June 3, 2021

Re: Responses to the following comments, EA Number EA1881, File Number AL2014:

- **Reclamation Plan, V2 Redline, PCD Manager, 11-25-2020**

- **Revisions to the Reclamation Plan based on DRMS Adequacy Comments:**
Adequacy Response dated 9/9/2019 as pertains to the Reclamation Plan:

FIGURE 2 - Reclamation Plan Map with HEC-RAS Cross Sections

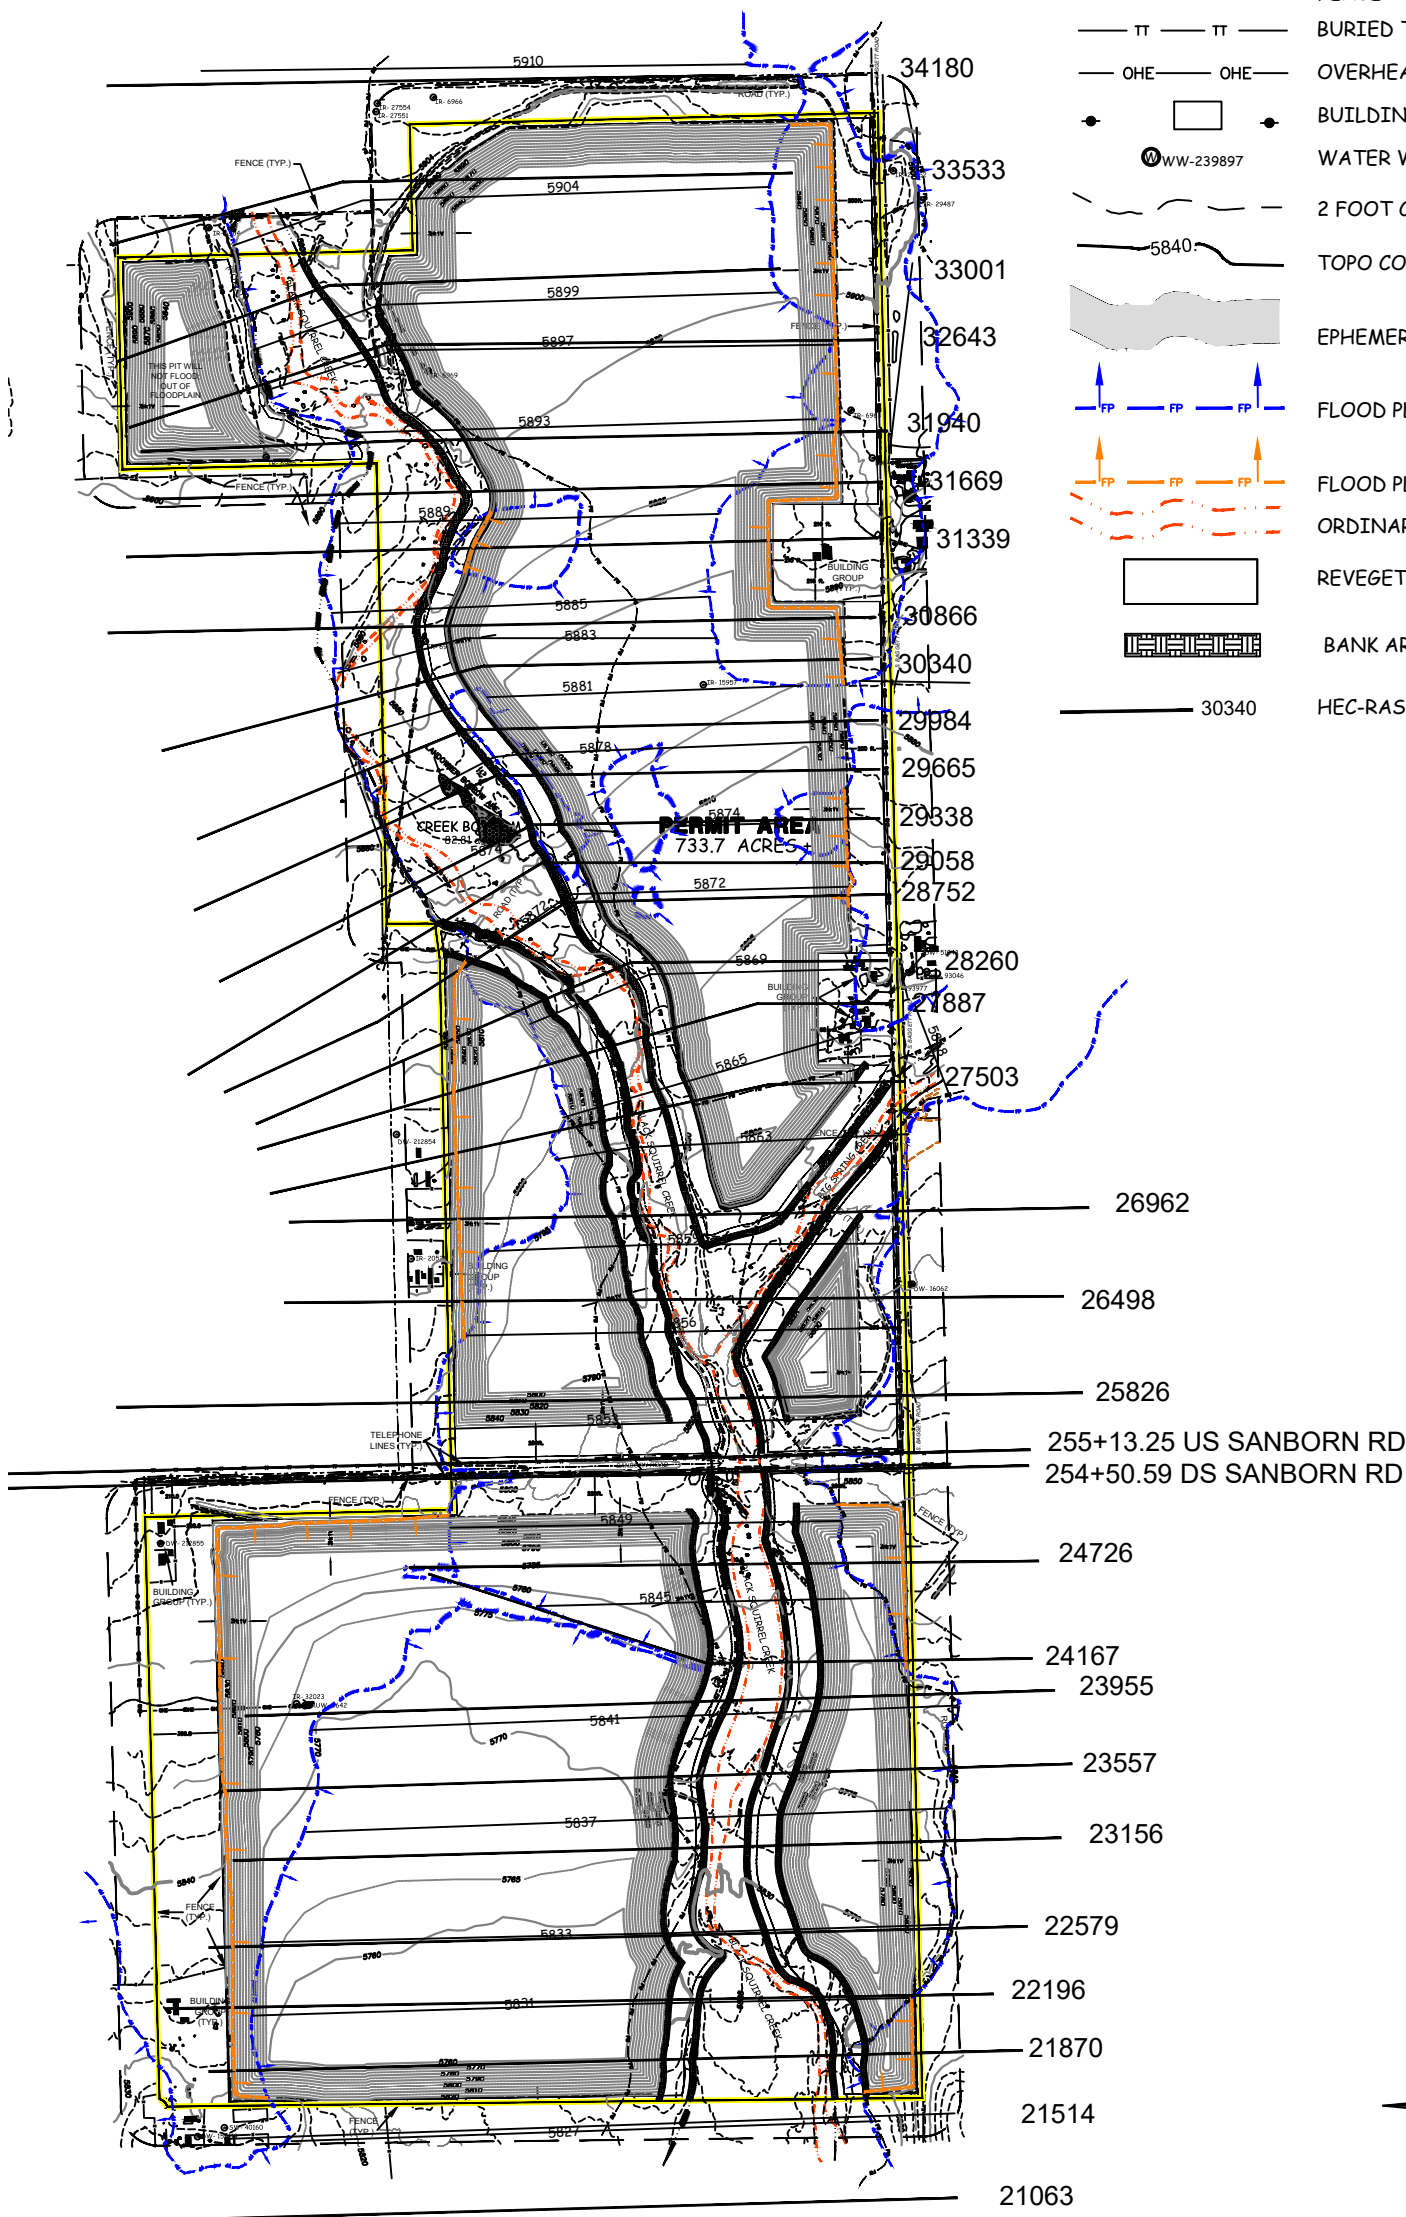
14. Proposed topography: There are no adequacy issues with Exhibit F other than the concerns the proposed final topography has on potential groundwater exposure and stream capture discussed in comments under Exhibits C, D, E and G in this letter. Please make appropriate changes to Exhibit F based on responses to these other comments.

I revised Map Exhibit F to show the new setbacks and bank armoring proposed.
